Himley Village : Energy Strategy Review

Document reference 16153-HYD-XX-XX-RP-Y-5001

Energy Strategy comments

Figure 3 - Passive design measures

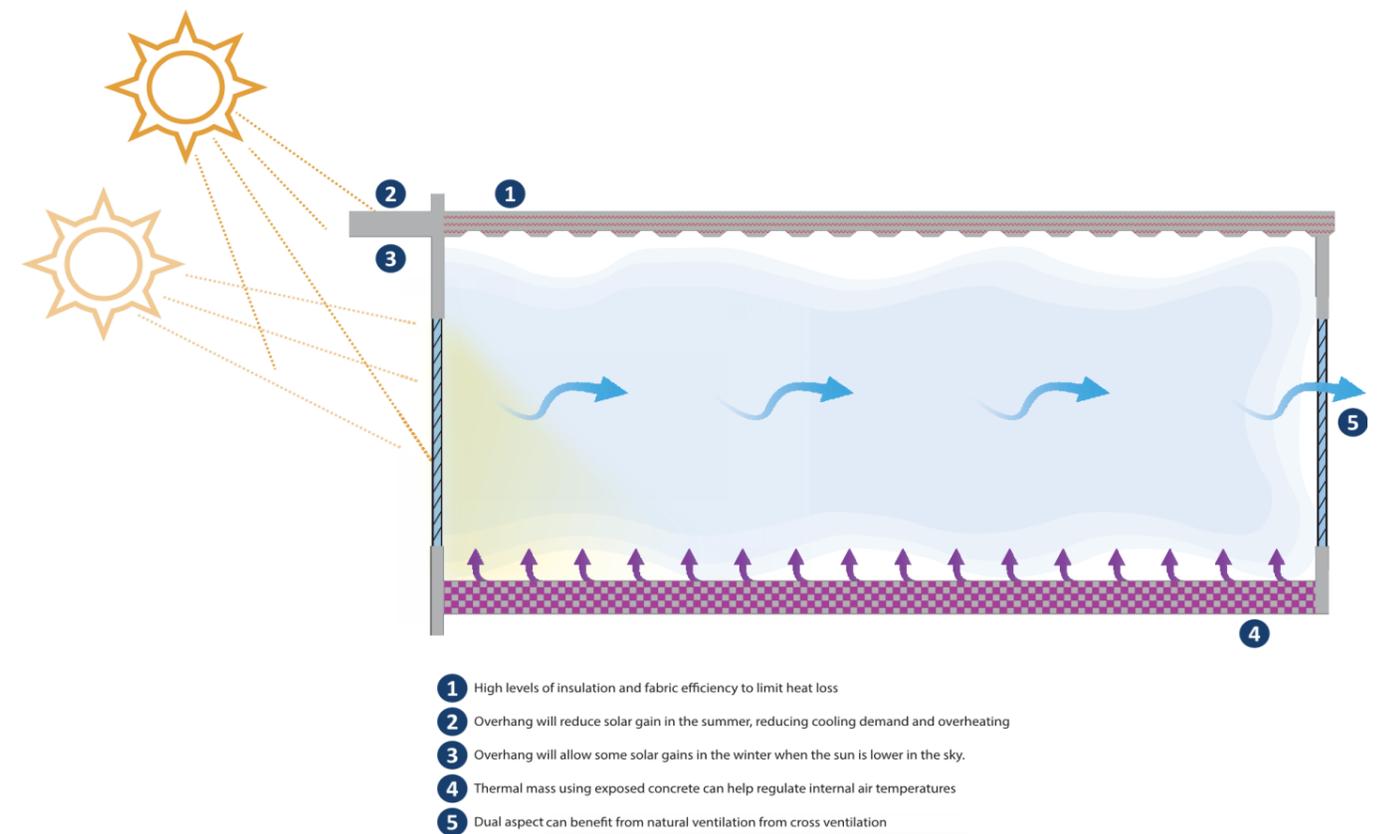
- a. Ground floor U-value (Could be improved from 0.15 to 0.13)
 - b. Air tightness (Could upgrade from 4 to 3 and still be a good way short of passive standards)

- 3) The Be Lean stage reduces space heating demand by 11% compared with the baseline, consistent with LETI recommendations, although a 15% reduction is possible and would bring the scheme closer to meeting BIC1

- 4) We support the use of ASHP to "Be Clean" and the COP of 3.5 that has been adopted
- 5) Even with the Be Clean ASHP, space heating demand is higher than best practice schemes @ 26kWh/m²/yr. The passive design approach could be taken further to achieve a space heating demand of closer to 15kWh/m²/yr. This does require skilled installers and skilled detailing, but is achievable and has been proven on other schemes in the county.
